Consultation Response from KC, Lead Local Flood Authority
2024/92727 Land adjacent to, Ashbourne Drive, Liversedge
Erection of residential development 67 dwellings with associated access, parking, public open space, landscaping and infrastructure
Date Responded: 3rd May 2026 Responding Officer: Paul Farndale Responding Ref: 3

Further to our comments of 31st December 2025, sufficient material has been submitted to show safe flood routing within the site and our **OBJECTION IS REMOVED:-**

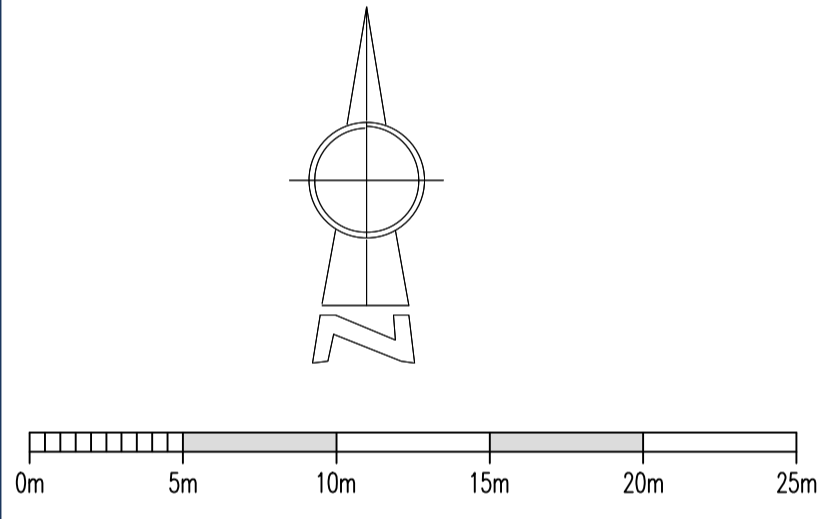
- External Works Layout 1/3 Ref: 159.004.08.01.RevA
- External Works Layout 2/3 Ref: 159.004.08.02.RevA
- External Works Layout 3/3 Ref: 159.004.08.03.RevA
- Flood Exceedance Layout Ref: 159.004.10

We note that a detention basin is demonstrated in the submitted Flood Risk Assessment but other drawings show two attenuation tanks. The latter is NOT APPROVED at this stage as green SUDS systems are favoured. Drawings such as the Flood Exceedance Layout listed above are for approval for FLOOD ROUTING ONLY and NOT for ATTENUATION DESIGN.

It has been demonstrated that space has been made for water so the finalised attenuation design can be conditioned.
